From: Amanda Scholes on behalf of Planning.Responses
Sent: 12 July 2017 09:18
To: Planning Scanning
Subject: FW: FG/198/16 - Plans

Mr Wood: Neither the latest Ground floor Plans nor the Street Scene, Sea Drive, both recently submitted, show any parking places fronting onto Sea Drive. But the covering minute from the architects, covering the revised plans (posted 29 June) refers to 12 parking places in all. The plan for the underground car park shows spaces numbered 3 to 12: are spaces 1 and 2 still intended to be on the ground floor, fronting Sea Drive? If so, why are they not shown on the latest plan and street scene? Isn't the absence of these prominent features very misleading for Members of the

STREET SCENE SEA DRIVE

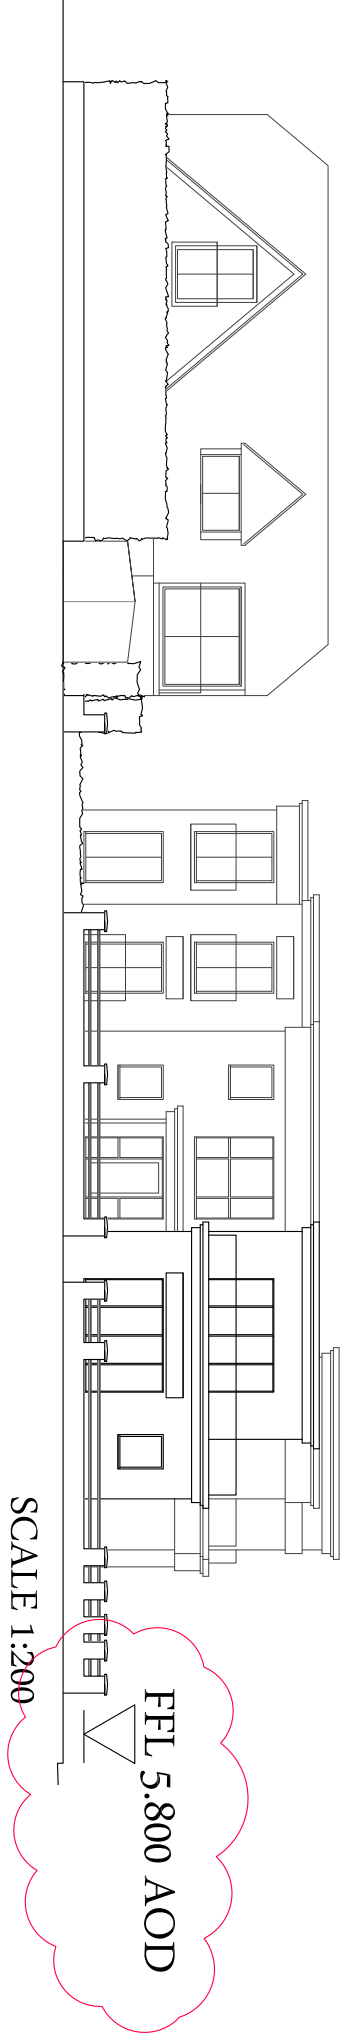
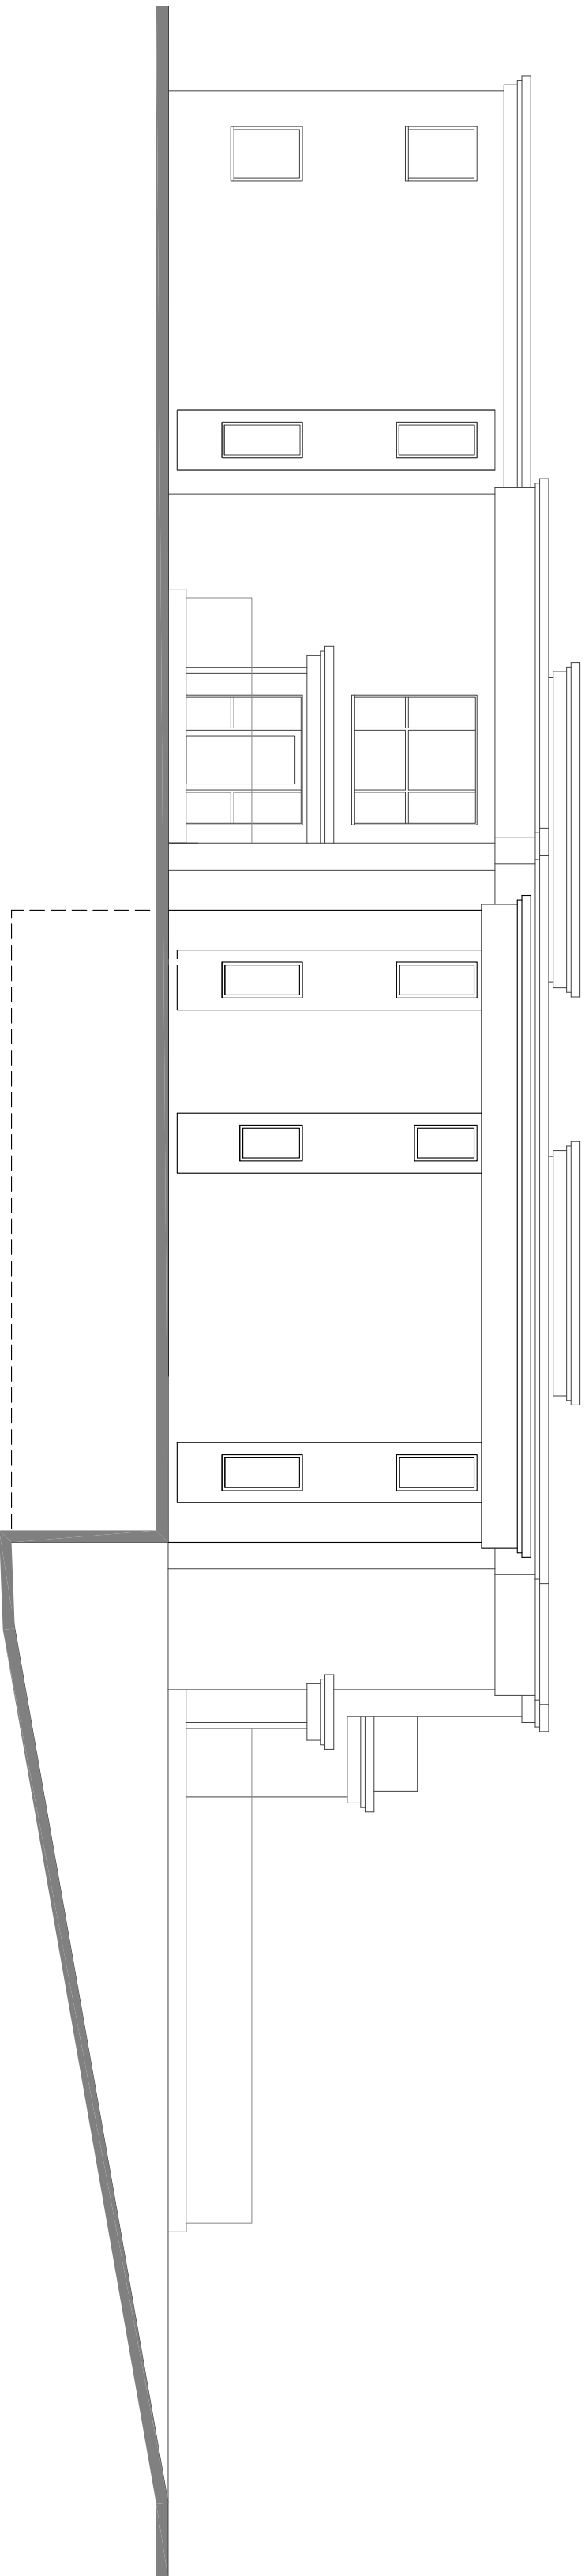
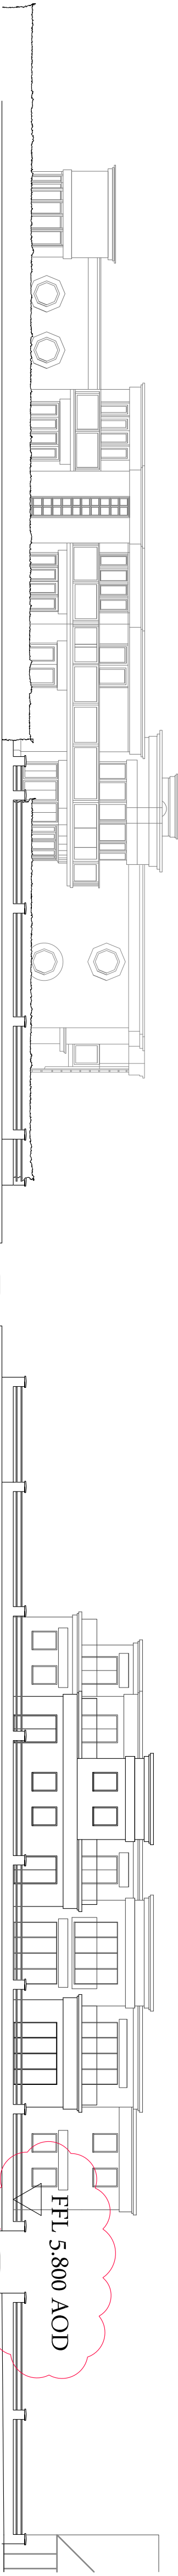
Mr Wood: Thank you. I can see the drawing you refer to (dated 11 April, isn't it?). In what sense is it 'approved'? I would still suggest that the latest Ground floor plan, and the Street Scene in Sea Drive, are misleading in that they do not show either the ground floor parking places (in the real street scene they would have cars parked on them) or the entrance to the underground car park. – Ed Miller

Yes they are still included and can be seen on Proposed Block Plan Dwg.no. 046/PL003 REV F Dated Apr 17 which is one of the approved plans.
